Application by Tritax Symmetry (Hinckley) Limited for an Order Granting Development Consent for the Hinckley National Rail Freight Interchange – Deadline 6 submission

Hinckley National Rail Freight Interchange

Leicestershire County Council Design Review Comments as presented to the Applicant team on 14.02.2024 and as discussed at a meeting with the Applicant team on 15.02.2024

Drawn:	J.Manifold	Reviewed:	S.Carter
BWB Ref:	NTT2814	Date:	07.12.23
Scale@A1:	1:500		
Drawing Status			
PRELIMINARY			
Project - Originator - Zone - Level - Type - Role - Number	Status	Rev	
HRF-BWB-HGN-HW02-DR-CH-0100	S2	P02

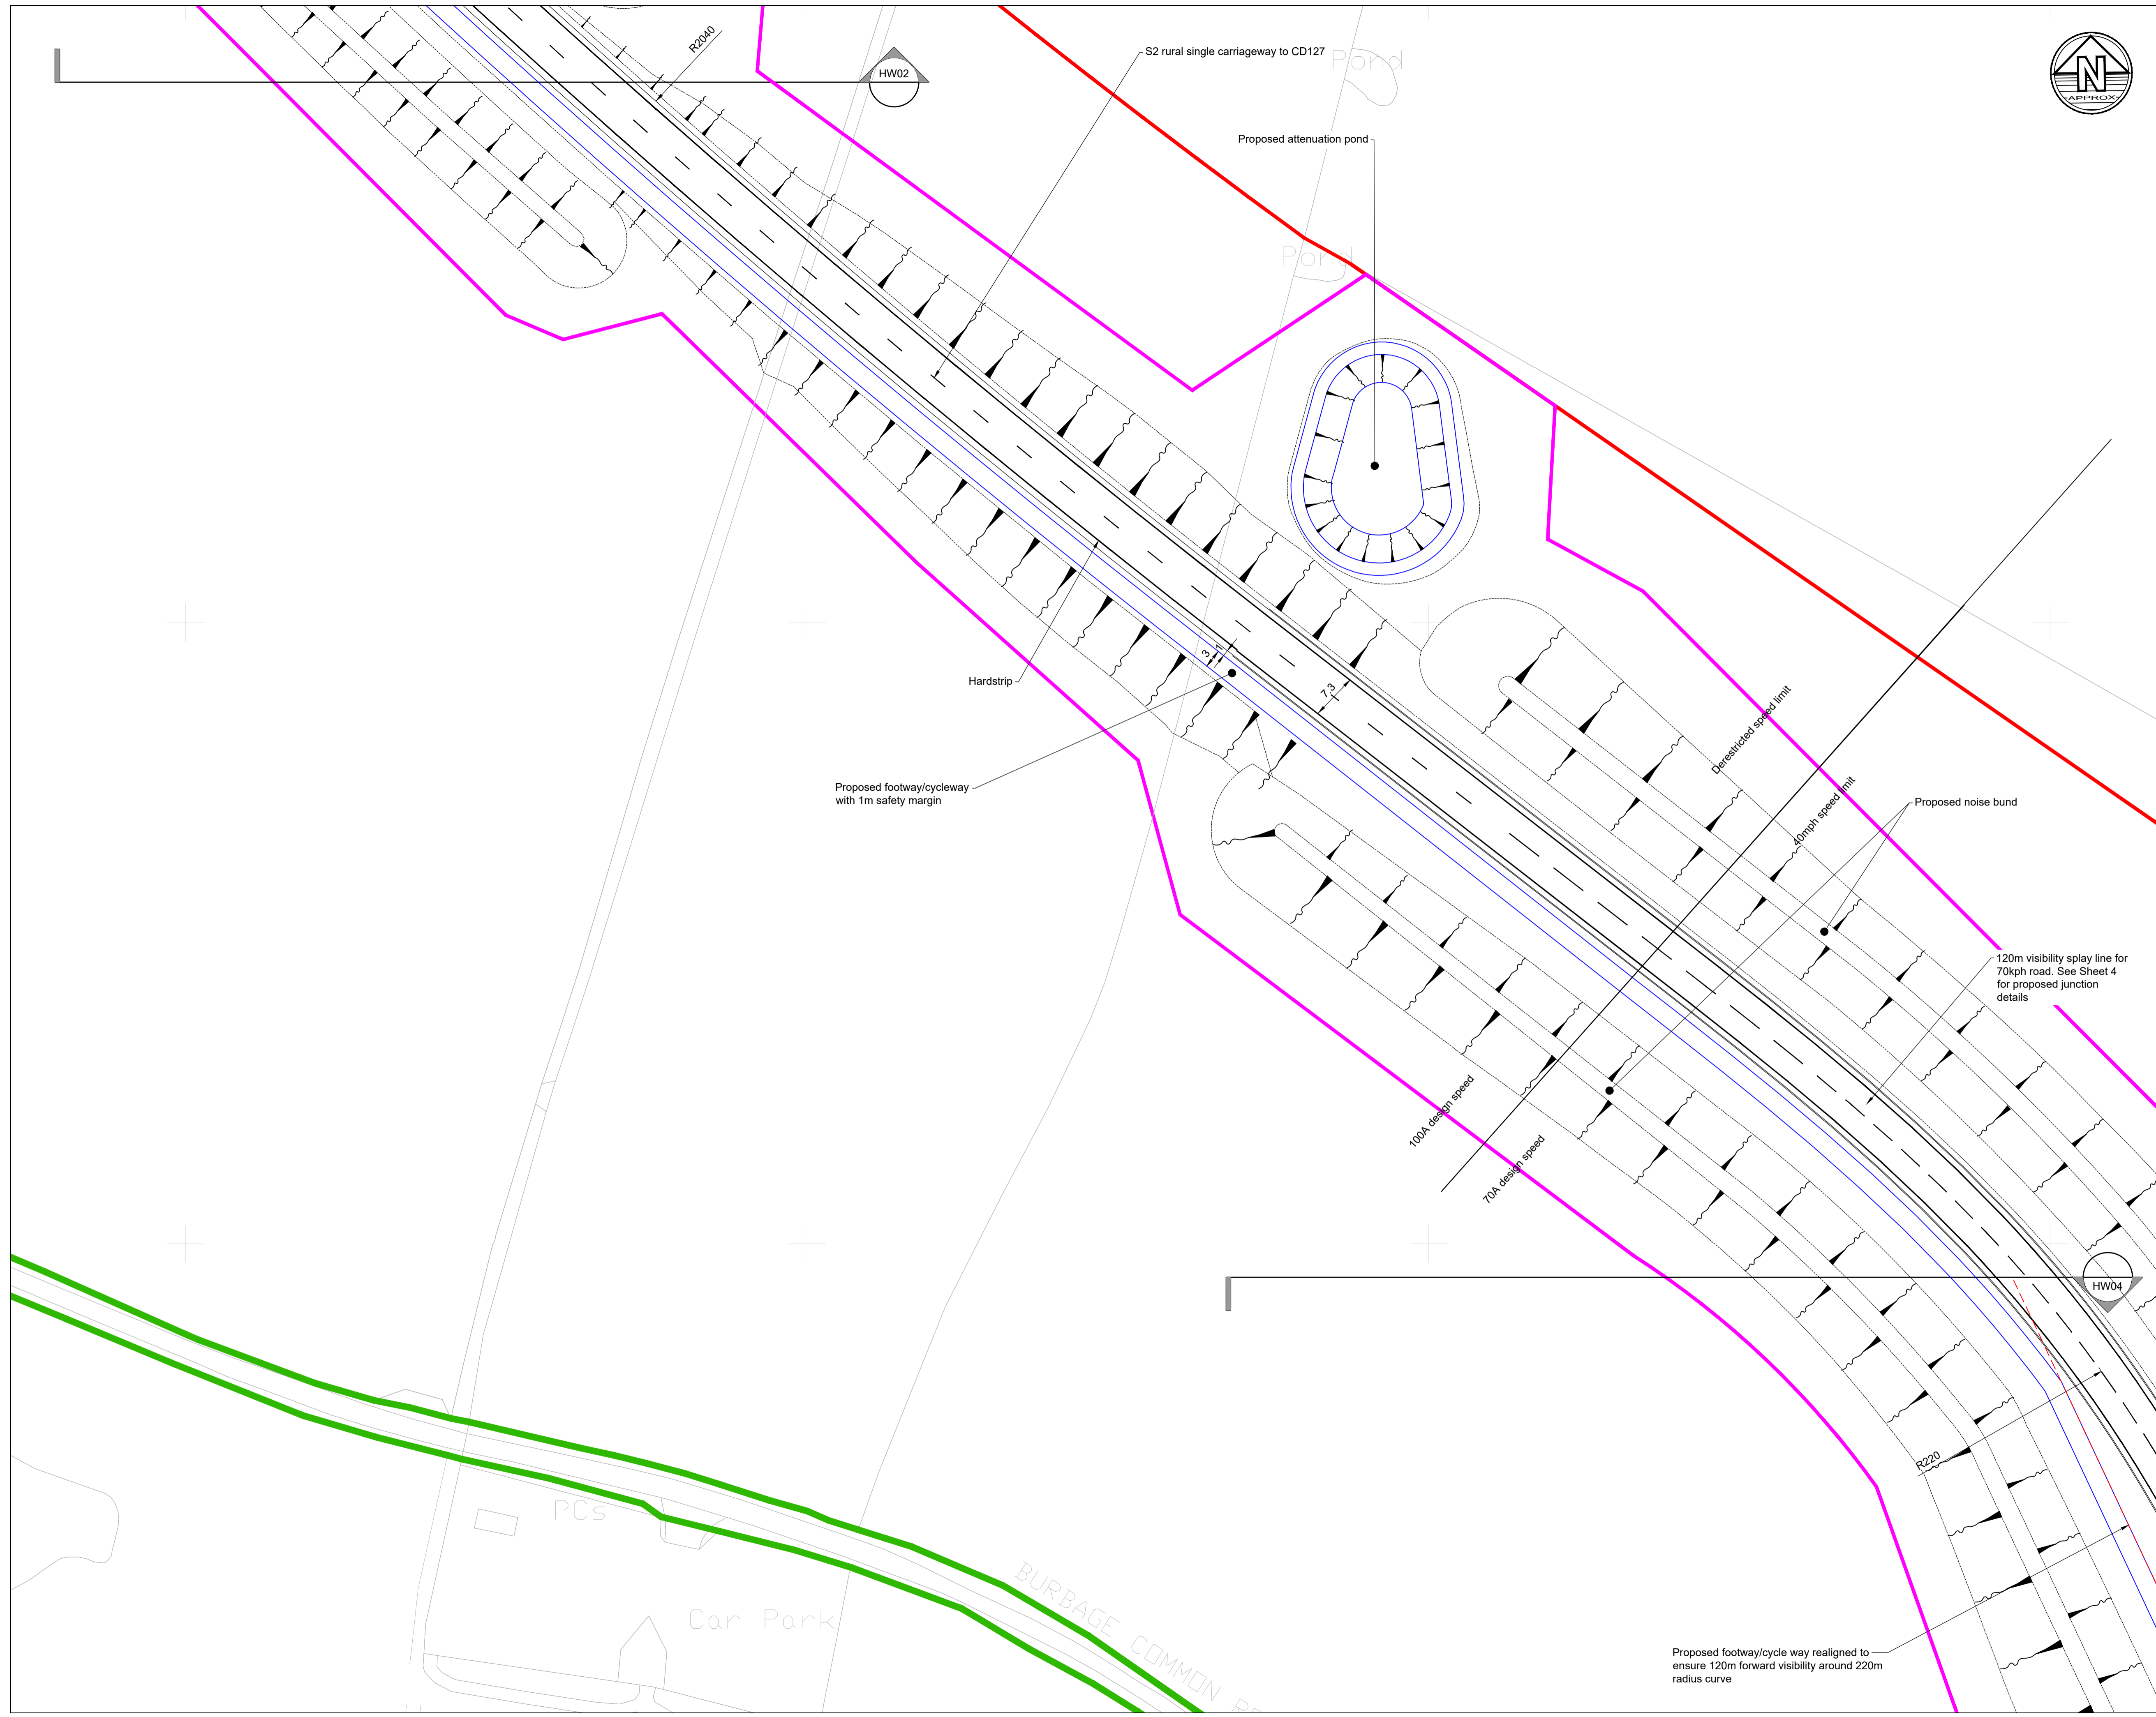
- 2.2.1 A merge length has been shown for the reduction from 2 lanes to 1 at the end of the segregated left turn lane. The proposed distance of the merge needs to be indicated on the drawing. Similar to comment 2.1.9 above there is concern regarding the proposed change in speed restriction at this location. Would it be better to have the merge inside the 40mph limit section rather than outside it?

- 2.2.2 Safety margin between cycle track needs to comply with LTN1/20 Table 6-1 requirements for 60mph speed restriction (2.0m absolute minimum). Buffer strip is only 1.0m wide which is OK for 40mph but not 60mph.

- 2.2.3 Outlets for the attenuation ponds not shown. Will the area of proposed attenuation ponds be enough for the surface water. Drainage strategy/calculations would be required for review by the LCC drainage team. This comment also applies to other drawings.

- 2.2.4 Existing watercourses appear to be crossed by the new road. Clarification required as to how these are to be treated. Overall drainage strategy to be advised. OWC would be required.

- 2.2.5 Mention of a footbridge on the OS in close proximity to the proposed site. Will this and any associated footway routes be impacted?

Drawn:	J.Manifold	Reviewed:	S.Carter
BWB Ref:	NTT2814	Date:	07.12.23
Scale@A1:	1:500	Status:	S2
Drawing Status	PRELIMINARY		
Project - Originator - Zone - Level - Type - Role - Number	Status	Rev	
HRF-BWB-HGN-HW03-DR-CH-0100	S2	P02

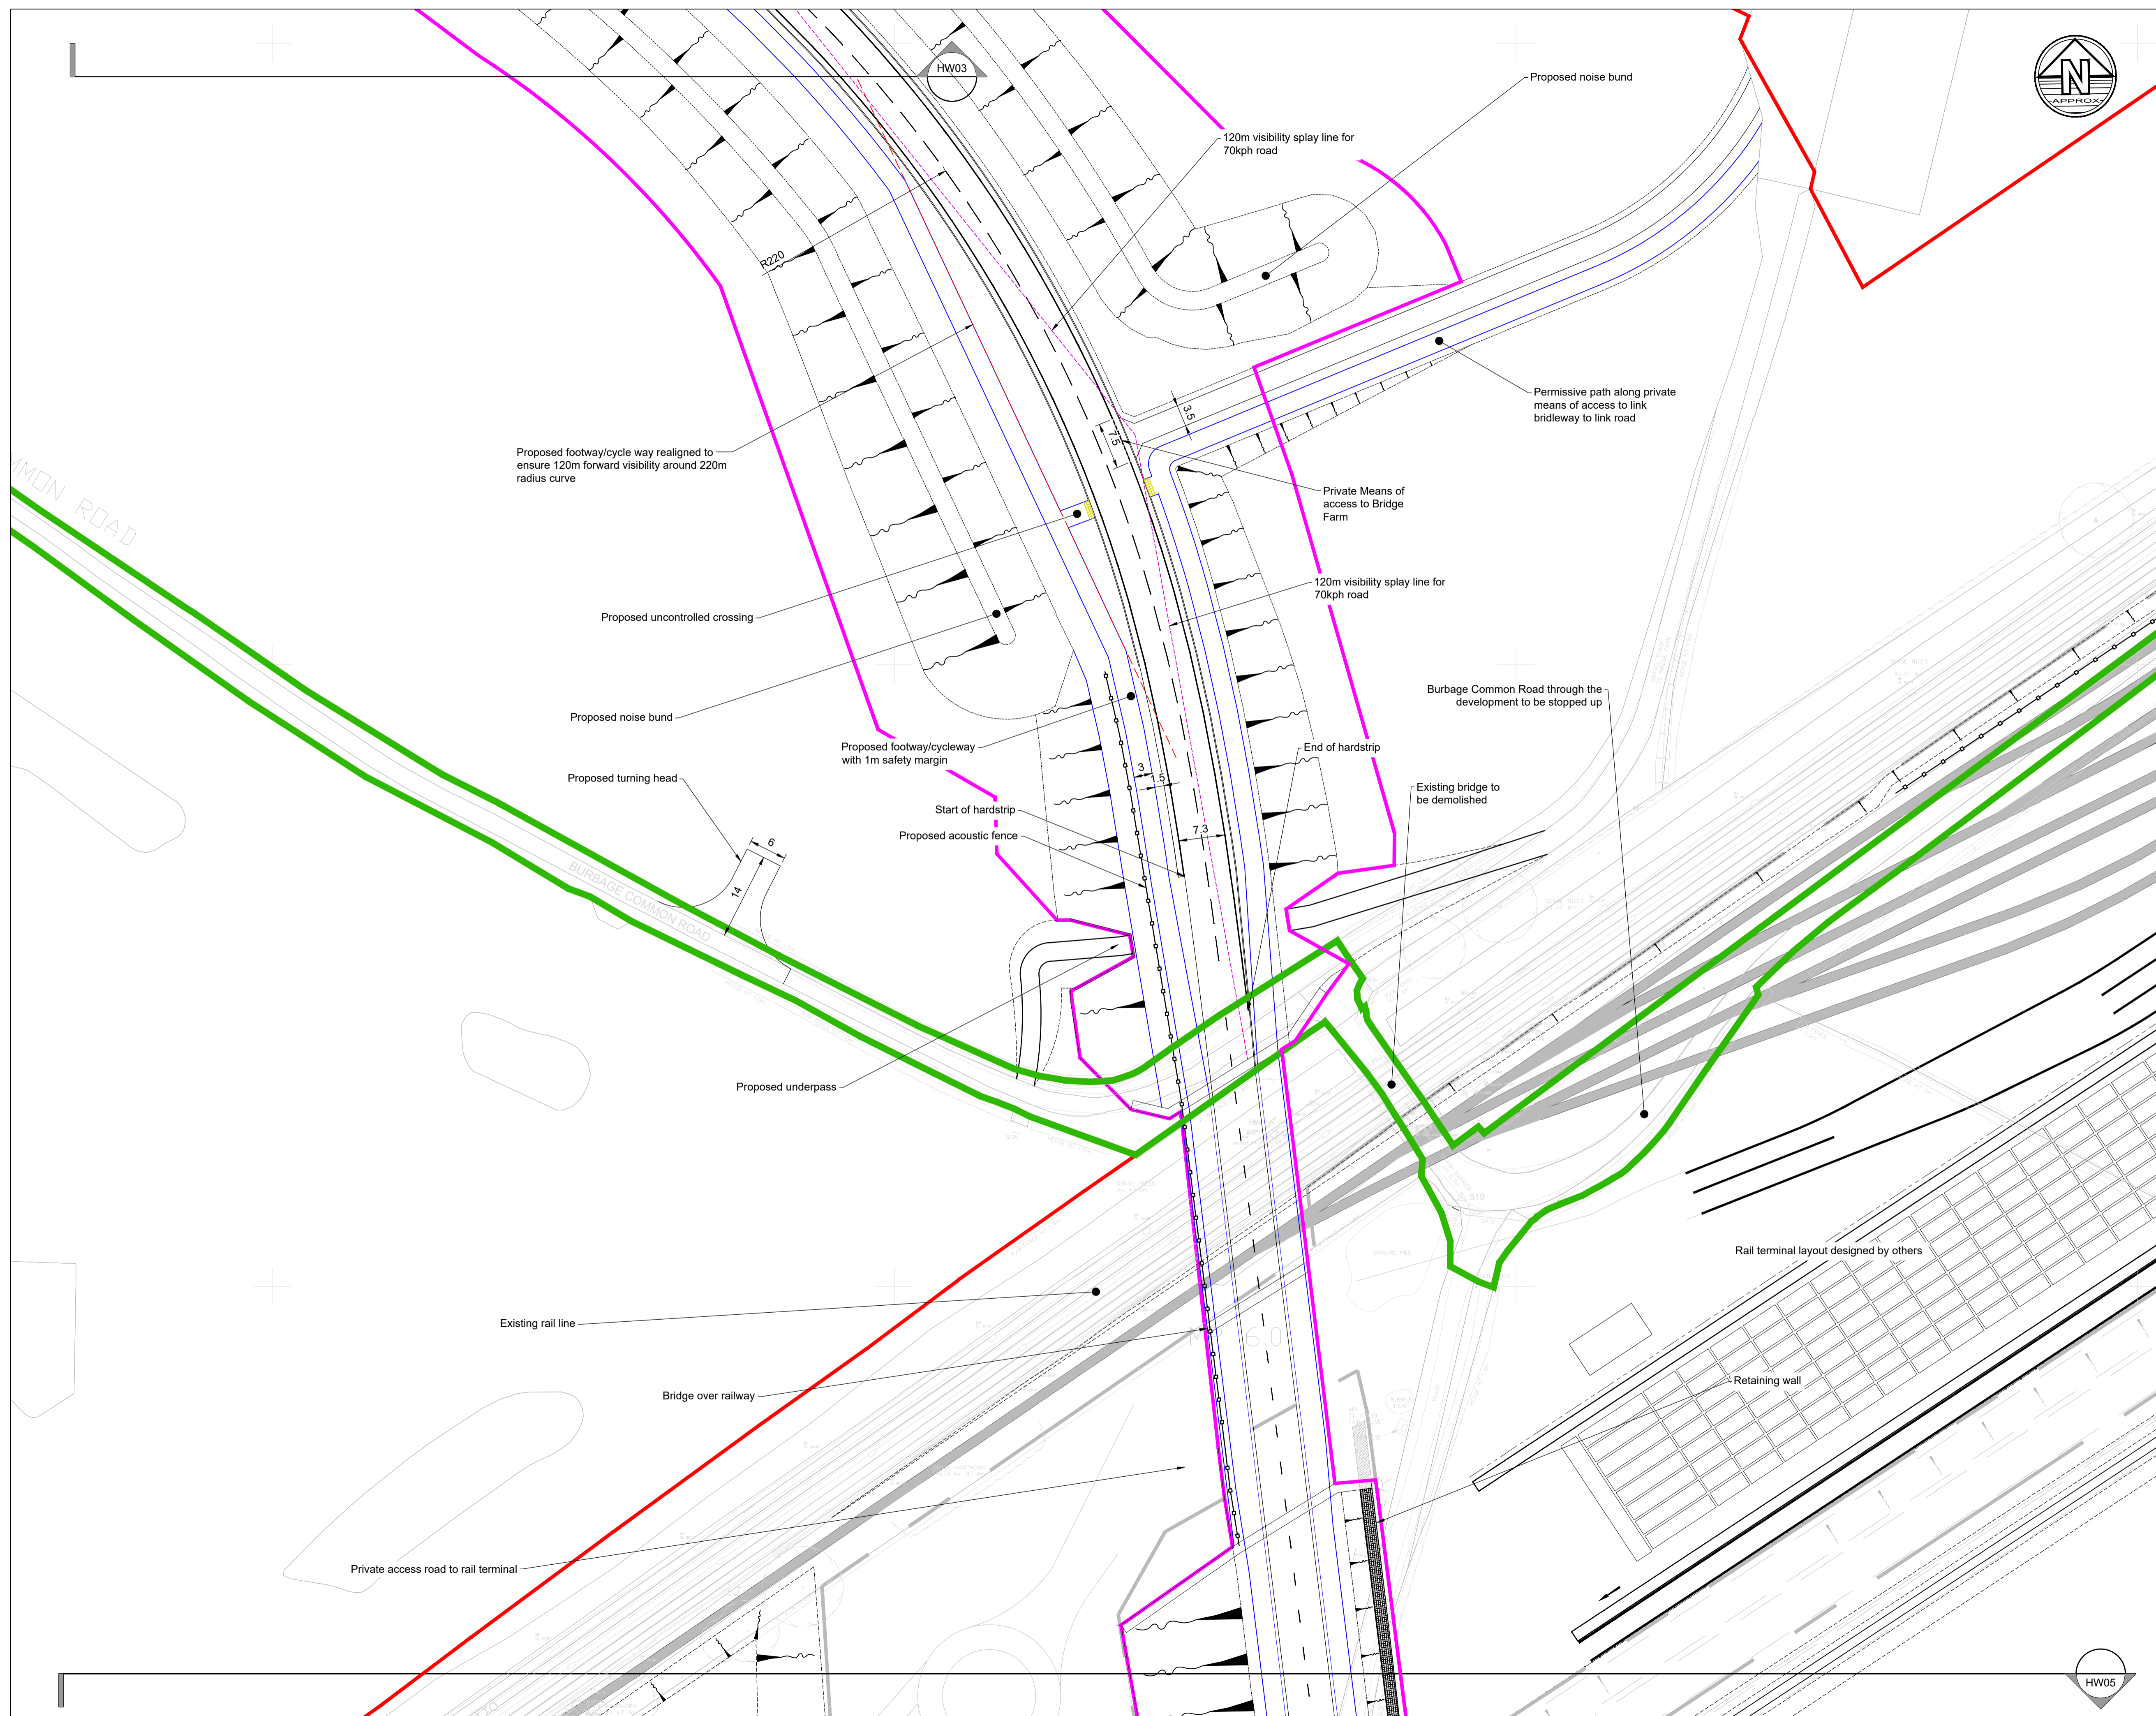
- 2.3.1 Proposed embankment – geotechnical investigation and earthworks design required.
- 2.3.2 RRRAP Assessment will be required. The designer will at this stage need to give consideration to VRS requirements, which will potentially affect visibility splays and the red line boundary.

- 2.3.3 The drawing indicates the road cross-section to be S2 rural single carriageway to CD127. This would require a 2.5m verge width which doesn't appear to have been provided to the Eastern verge.

- 2.3.4 The 60mph section ends here which means it is relatively short so is it worth retaining. Simplify to 40mph throughout the section from drawings 1 to 4?

- 2.3.5 Similar to comment 2.2.3, outlets for the attenuation ponds not shown. Will the area of proposed attenuation ponds be enough for the surface water. Drainage strategy/calculations would be required for review by the LCC drainage team. This comment also applies to other drawings.
